BCA ASSESSMENT REPORT

PORT BOTANY INDUSTRIAL ESTATE

Revision 02

Date: 1st October 2014

SITE PLAN- GROUND
1:750 @ A1
October 2014
4244_DA-02

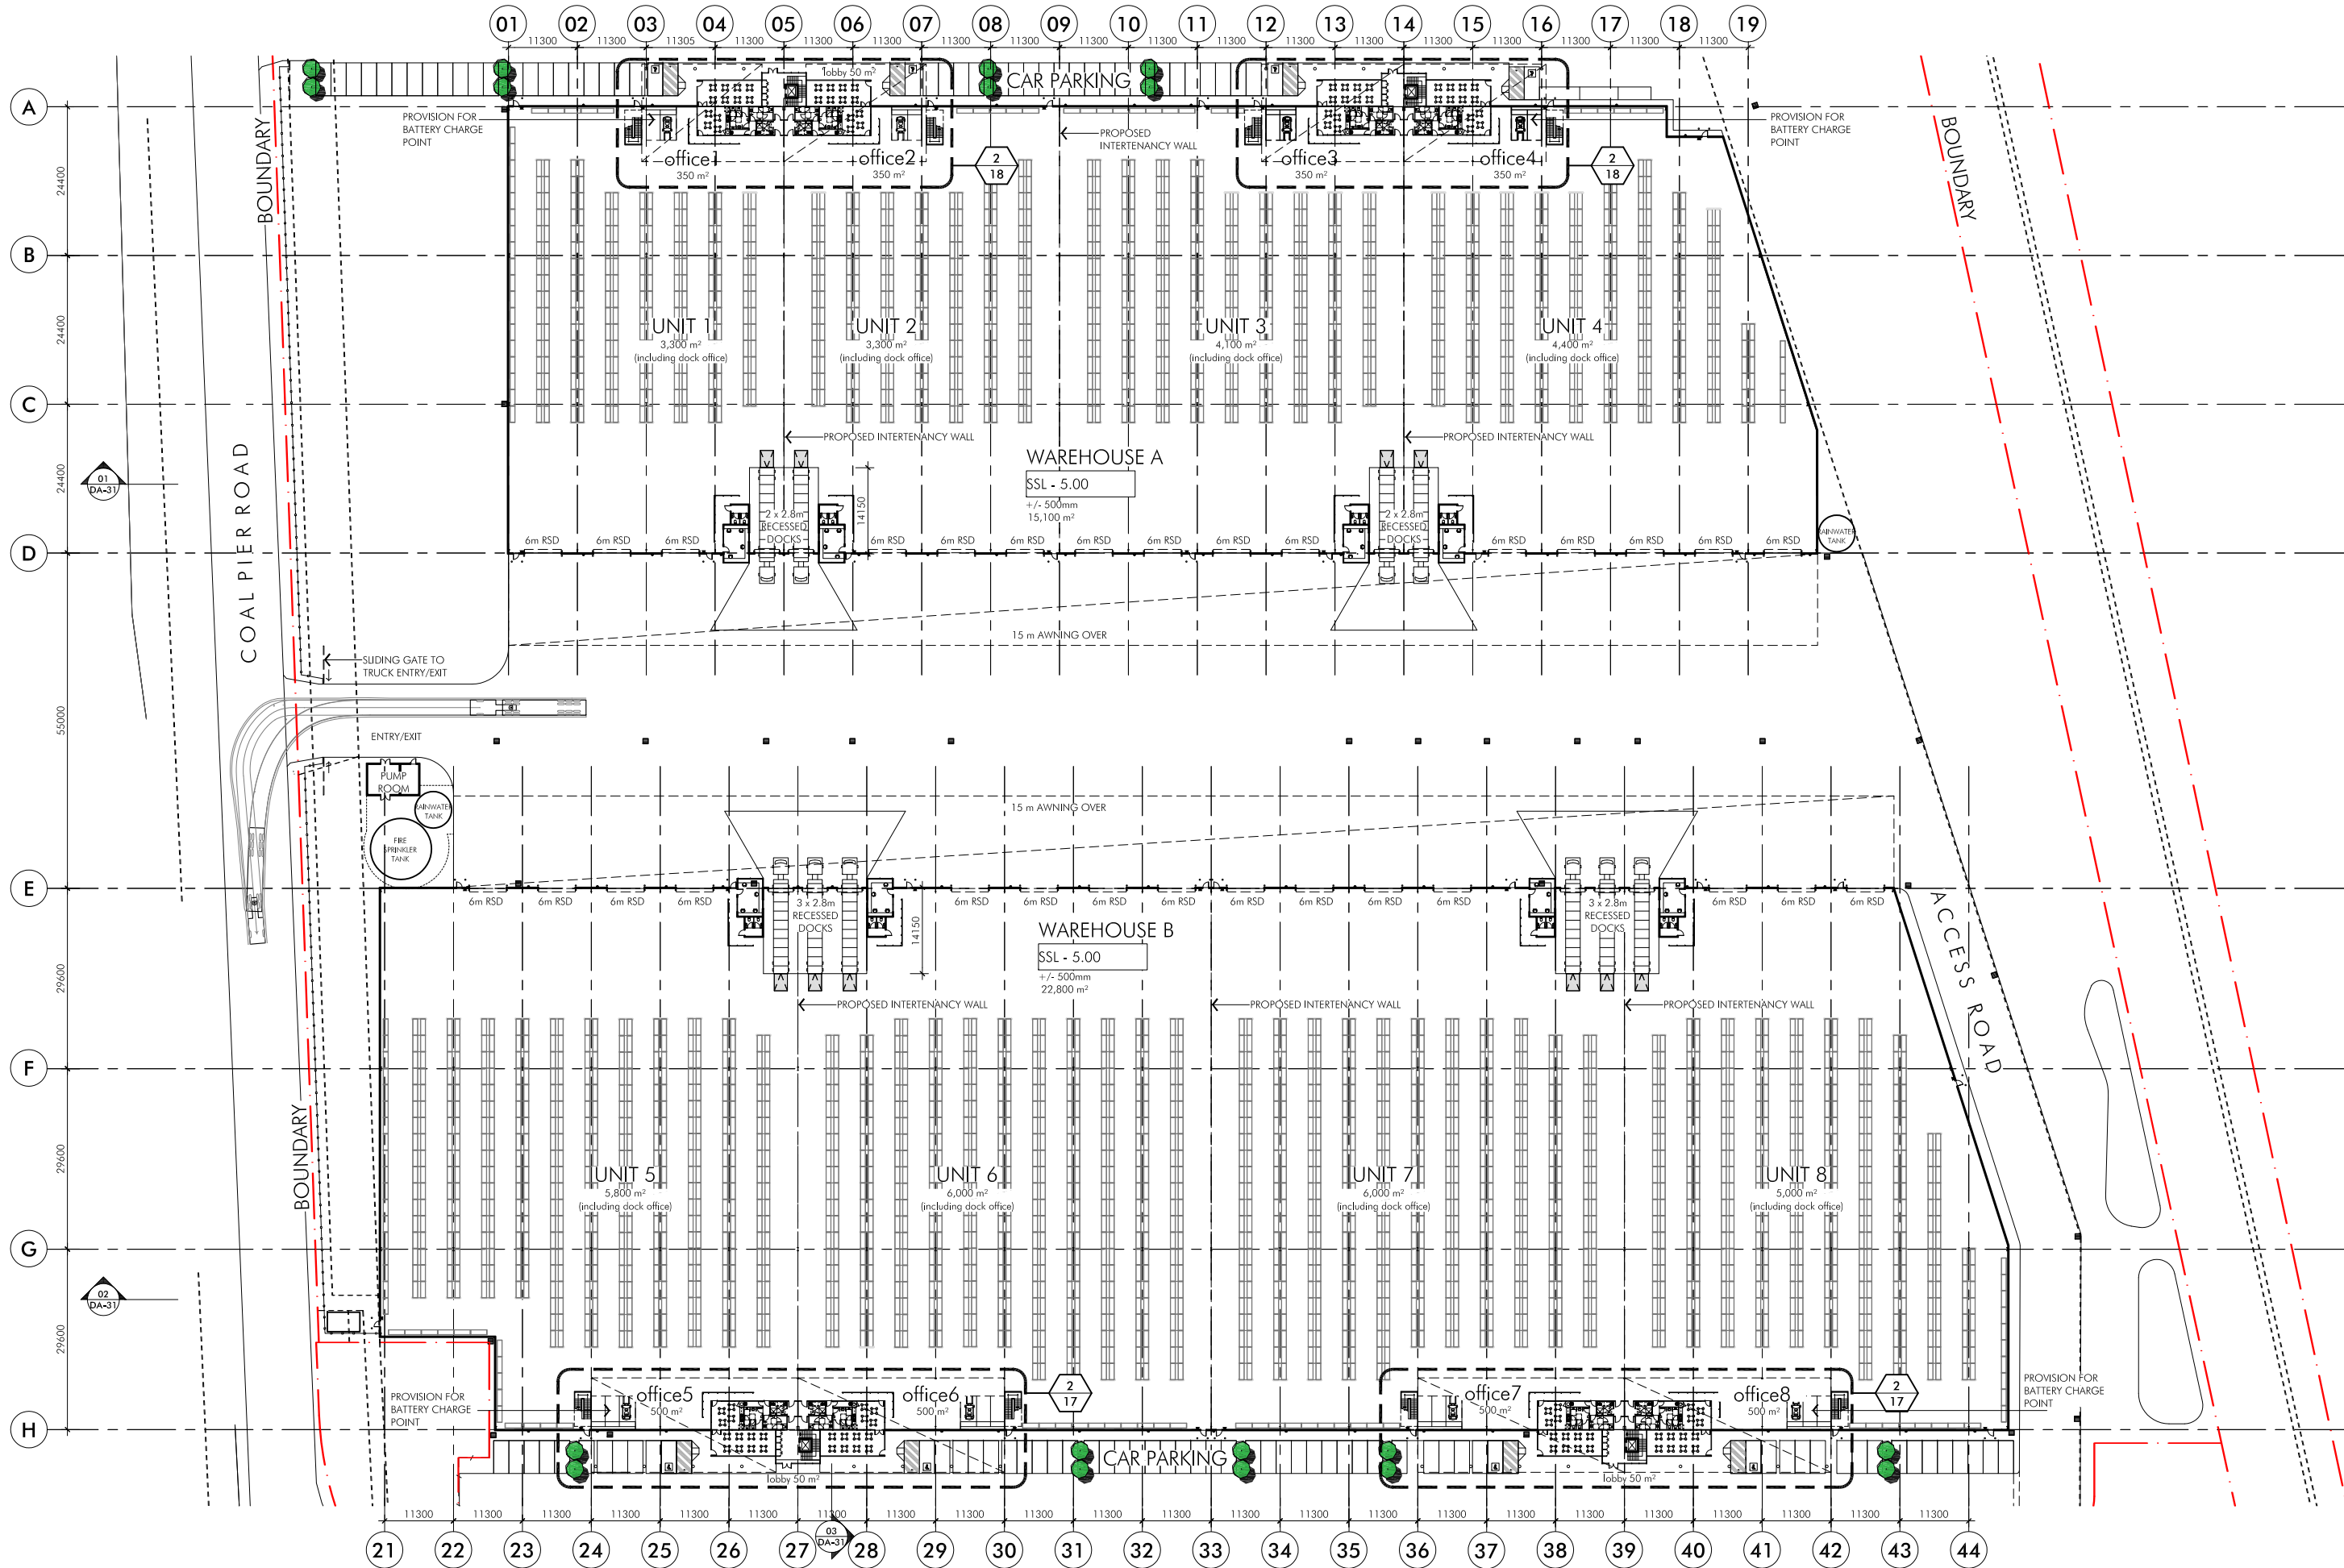
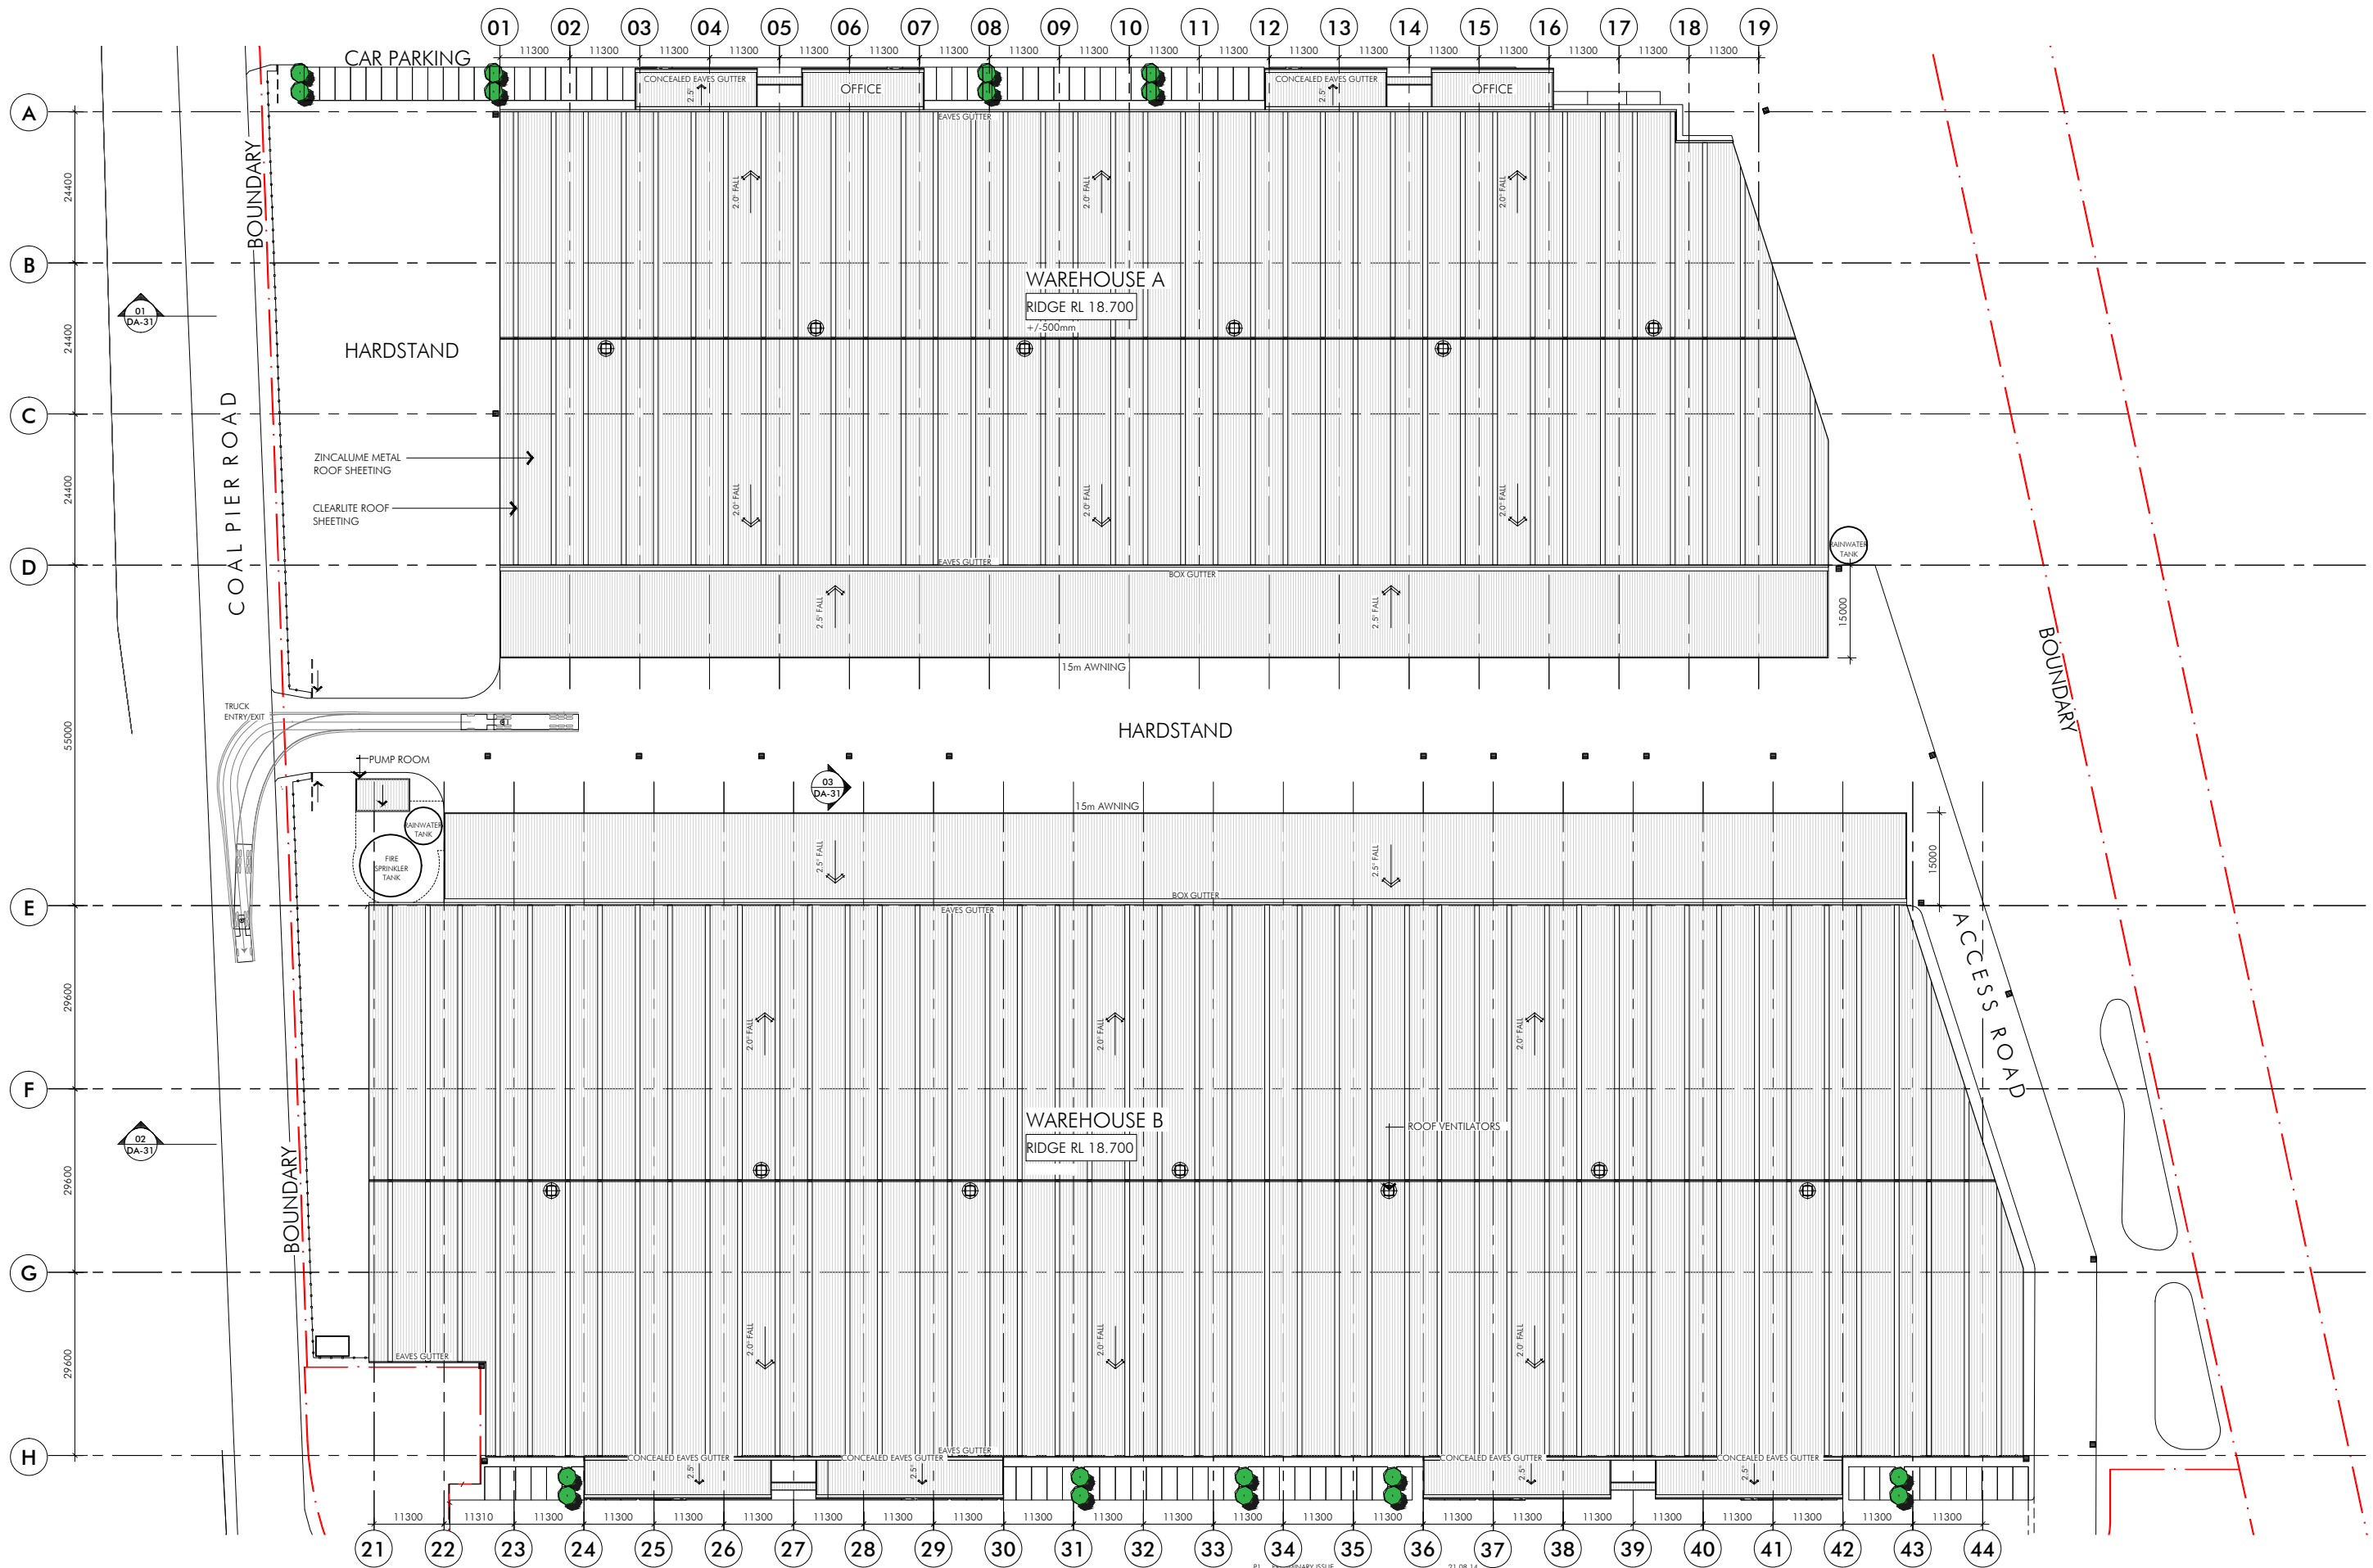
Comments: The perimeter access roads and turning bays will generally be designed to comply with the BCA and Fire & Rescue Guidelines (Policy No.4) however a few departures have been identified as matters requiring further attention by the project Fire Safety Engineer.

Alternative Solution: The following non-compliance issues are required to be addressed as an Alternative Solution by the Fire Safety Engineer - refer to the numbered points below and the diagram over page for details of the proposed non-compliance issues:

- 1. Vehicular Access will only be provided around three (3) sides of the building and is therefore discontinuous along the Eastern side due to site constraints associate with the Flood Storage Areas on the site. Suitable turning provisions will however be available along the Southern and Northern sides to facilitate brigade operations.
- 2. Additionally, the Western side will have the furthest part of the required 6m access road located at distances greater than 18m from the external walls of the building (approx.47m).

- 3. Vehicular Access will be provided around all four (4) sides of the building however the Western & South-Western side will have the furthest part of the required 6m access road located at distances greater than 18m from the external walls of the building (approx. ranging between 21m and 42m).
- 4. Additionally, access to the site from McPherson Street necessitates brigade vehicles crossing via a separate allotment which will have a Right of Carriageway.

- 5. Access to the site will be controlled access and there will be secured access entry and gates at the main entrance.

Note: The above non-compliance issues are required to be addressed as an Alternative Solution by the Fire Safety Engineer to demonstrate compliance with Performance Requirements CP9.
